**Howerton Services, PLLC**  
**License # P-1716**  
3513 Cathedral Bell Road  
Raleigh, NC 27614  
(919) 270-3460

August 26, 2025

Subject: 123 Basin Street  
Fuquay Varina, NC 27526  
Plan Revision Letter  
Harnett County Permit #: SFD2503-0073

1st Floor Plan

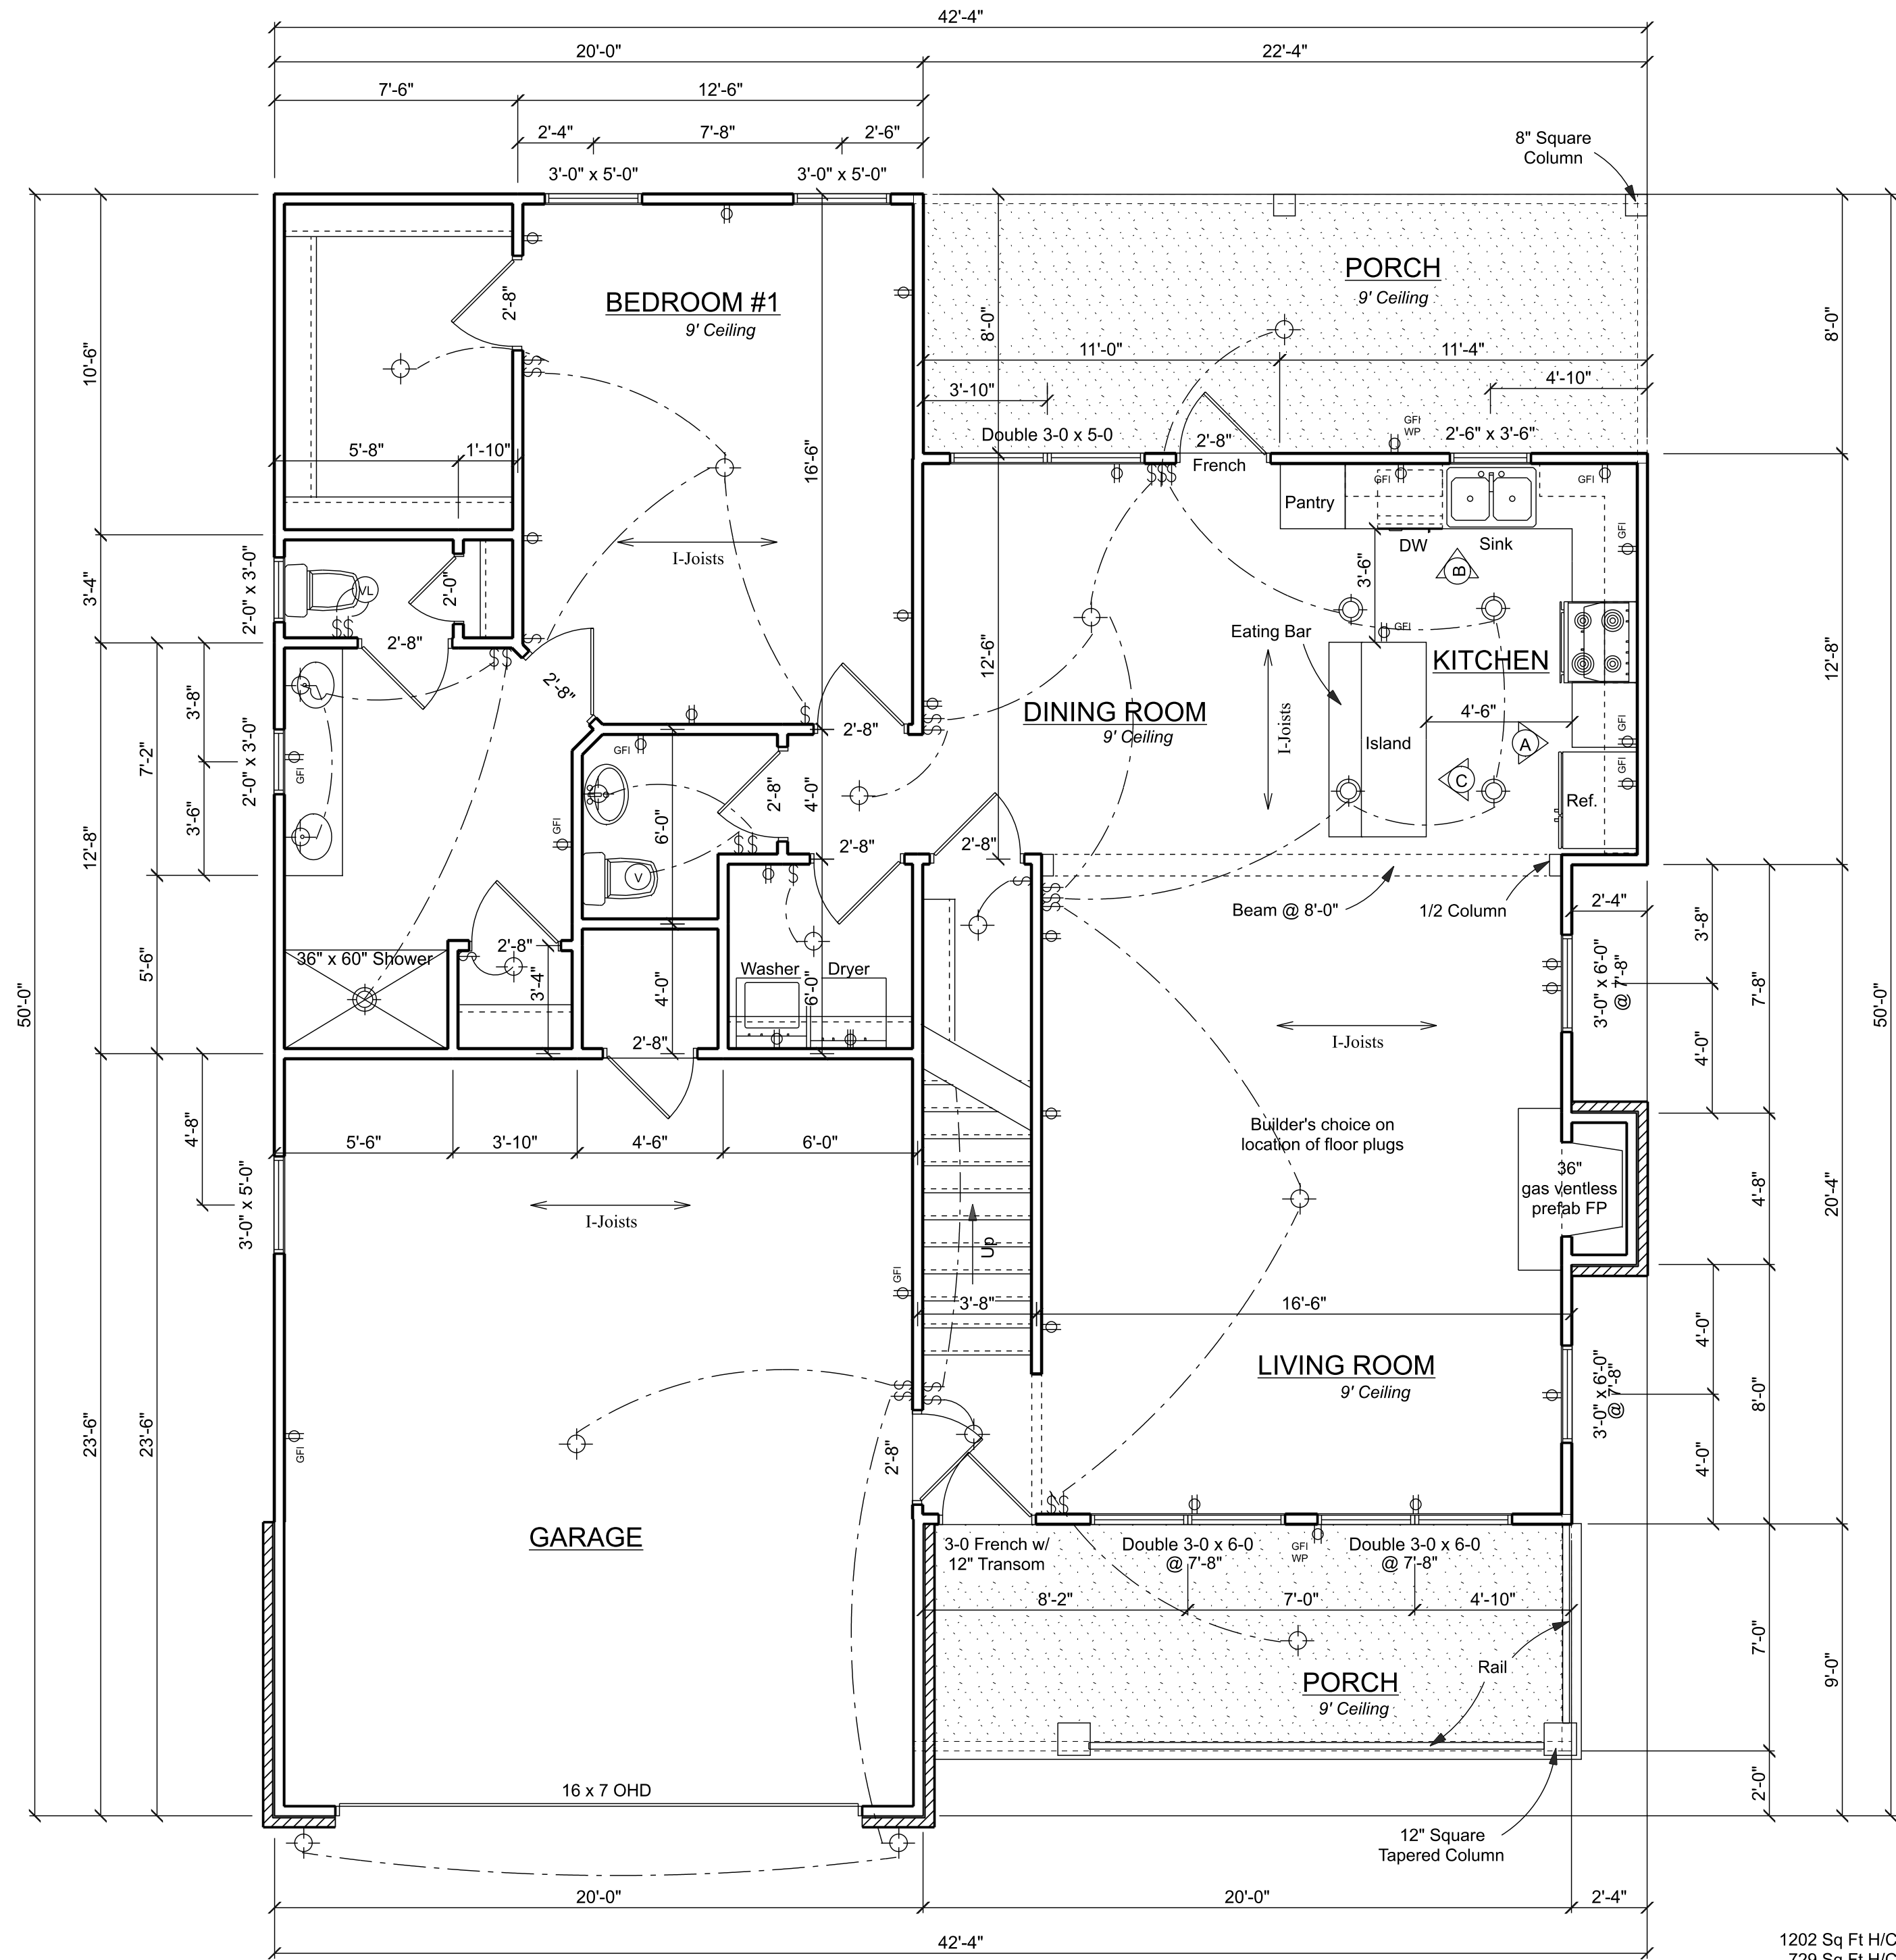
- The Contractor modified the interior foundation wall of the Garage to install a room. A double 1 3/4"x 9 1/4" LVL beam was installed in the ceiling to span the gap between the new corners of the modified interior foundation wall. The new stud wall is attached to the concrete slab of the Garage. This stud wall is not load bearing. This plan change is acceptable.
